**From:** Sarah Fletcher <fletchsa1@gmail.com>  
**Sent:** Sunday, March 26, 2023 4:51 PM  
**To:** Roxanne Navrides  
**Cc:** Ryan Harriman; Suzanne Skone; Dan Thompson; Mike or Susie Cero; Carv Zwingle; Thomas Acker; Council; Traci Granbois; Robert Medved; Jessi Bon; Alison Van Gorp; Bio Park  
**Subject:** Re: Public Comments SUB 19-002/Boys and Girls Club Long Subdivision

Dear Ryan, I am a long-time resident of Mercer Island, and have been involved in this subdivision since the property was originally purchased from the Boys and Girls Club, a very unfortunate situation. The purchasers never honored their promise to build and provide ballfields for Island youth and the city never required a deed on the property despite the fact the Boys and Girls Club, city, and private citizens spent several million dollars to build Peak rather than buy this parcel for roughly the same price. Many citizens, and council members, felt deceived.

2/16/23
JOB NUMBER: 13-118
SHEET NAME: RS-01
SHT 6 OF 9

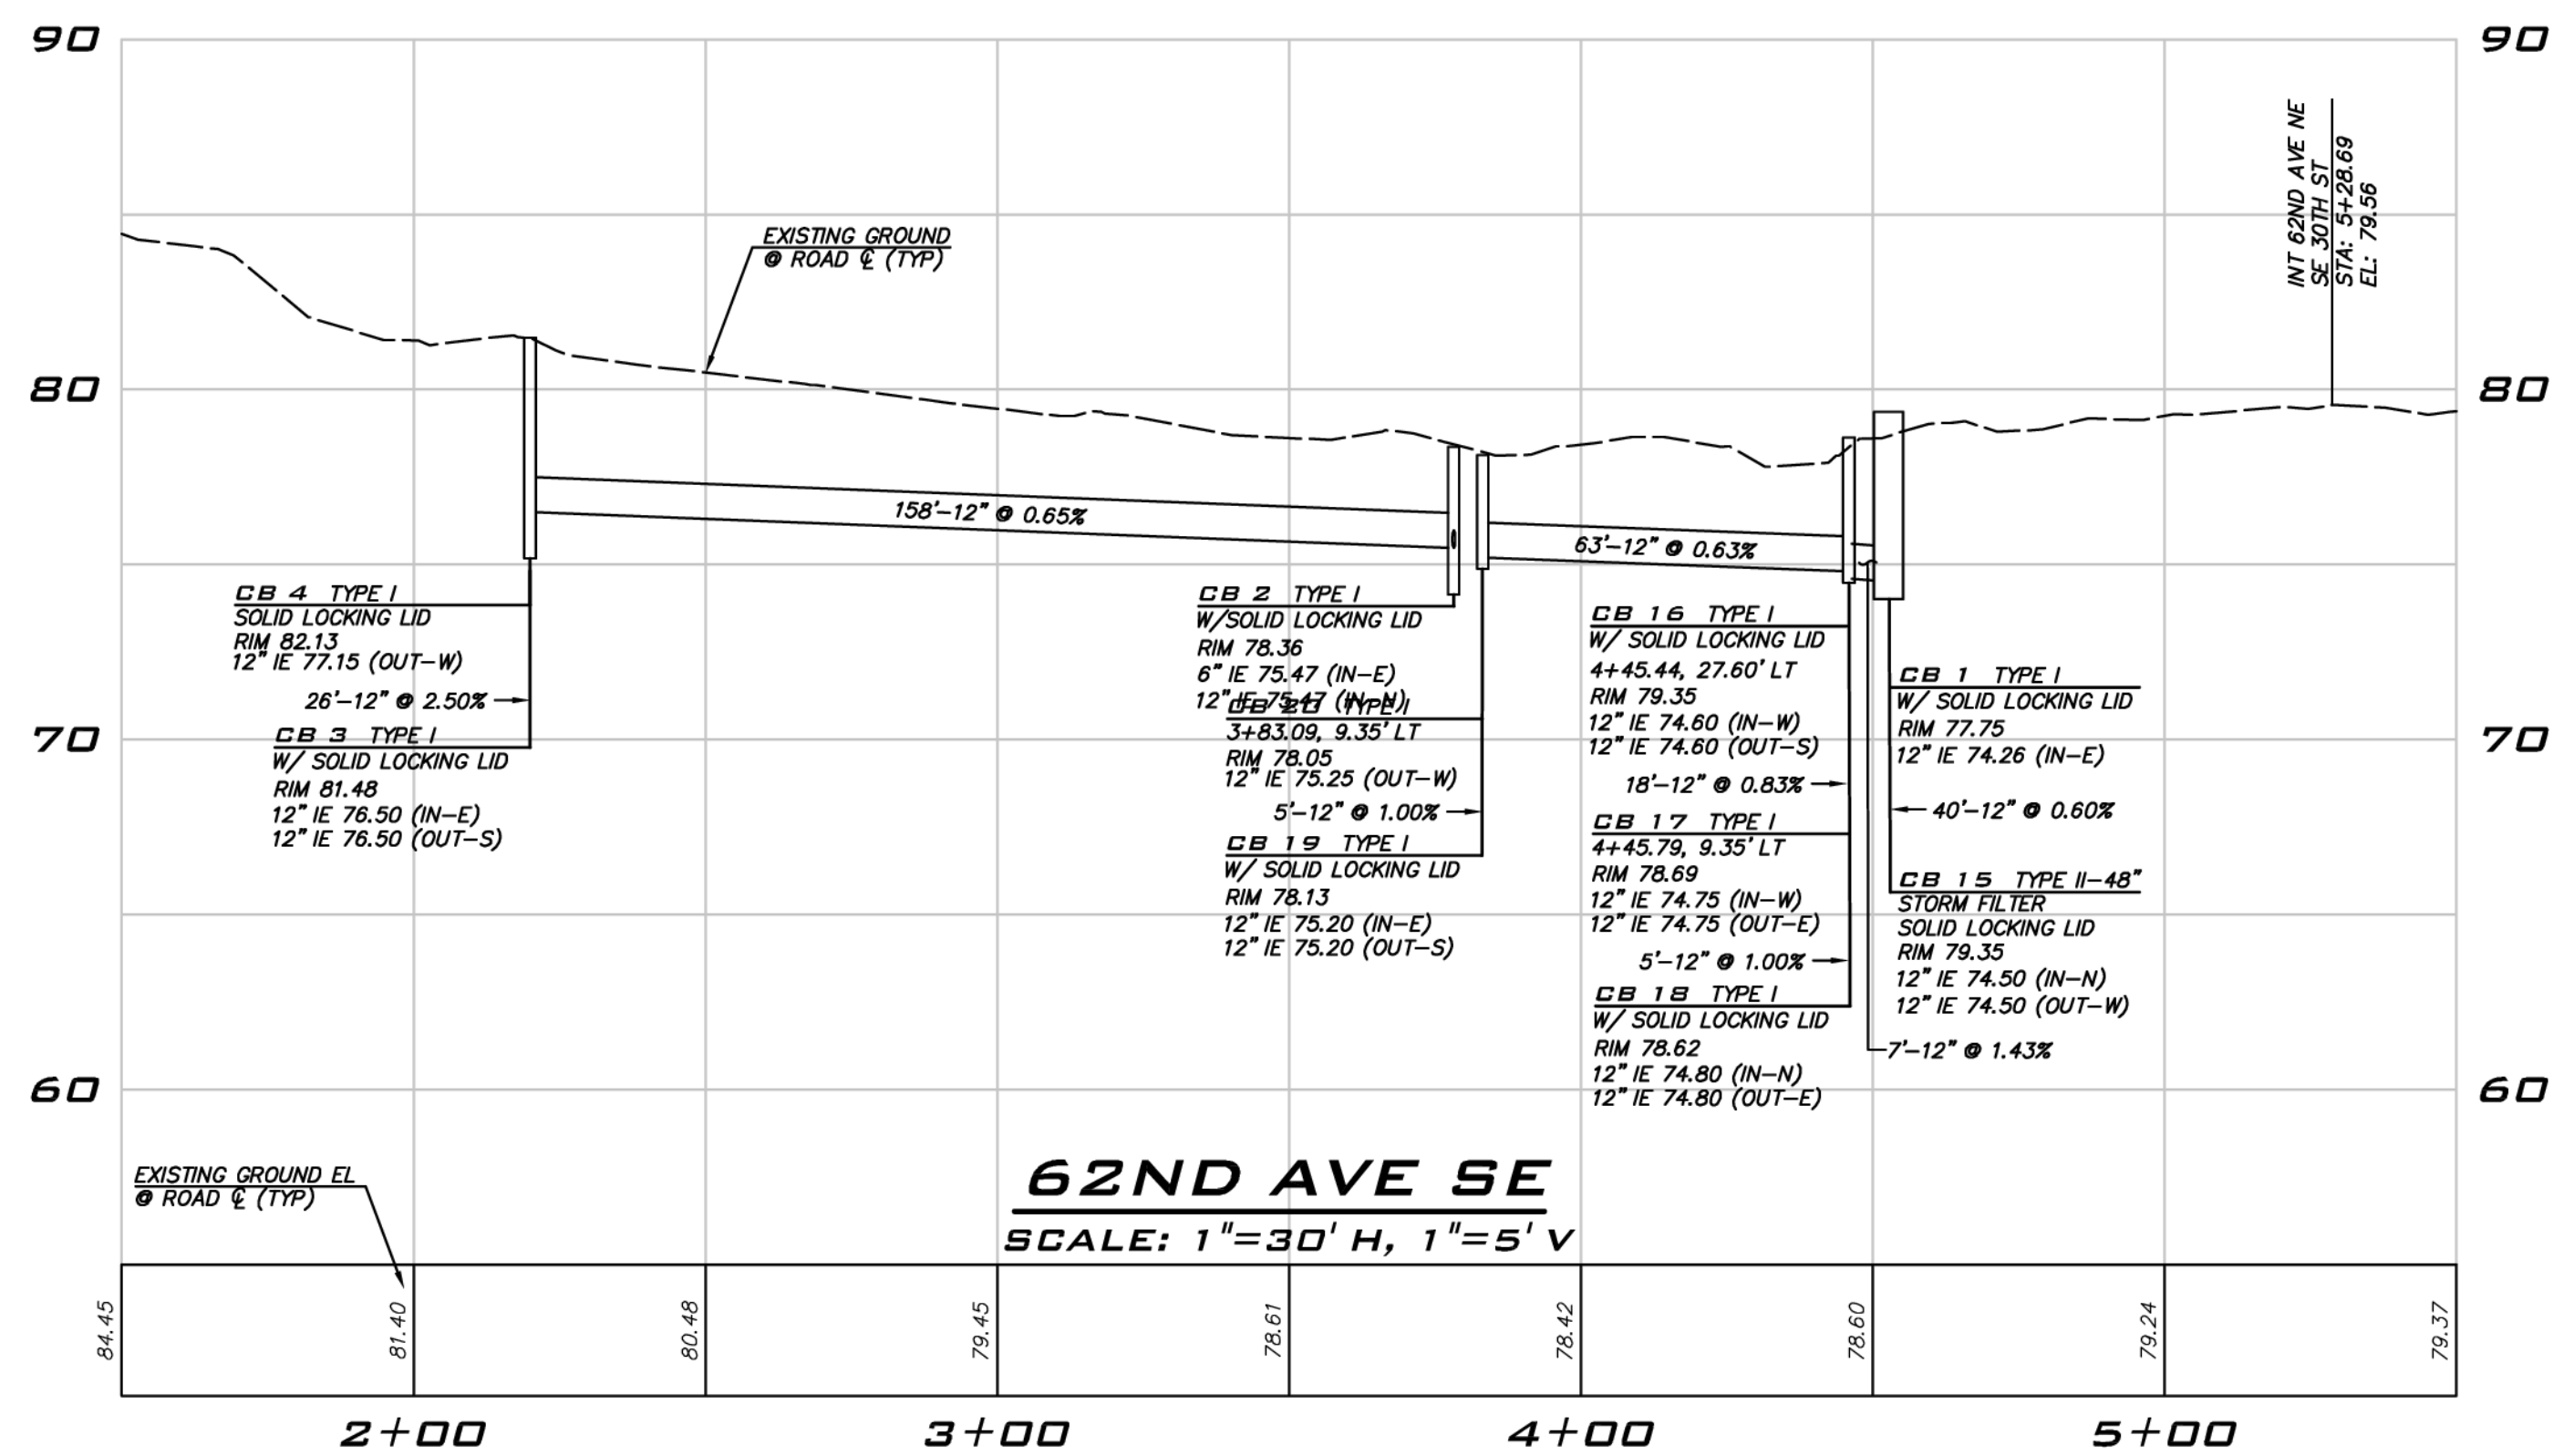
B. Ingress and egress should be by internal road for each house. The applicant no doubt does not like this since the internal road counts against lot area and lot coverage limits, but in my opinion the current plans are a danger to those walking or biking along adjacent streets. There is some internal access to some lots, but all access should be by an internal access road.
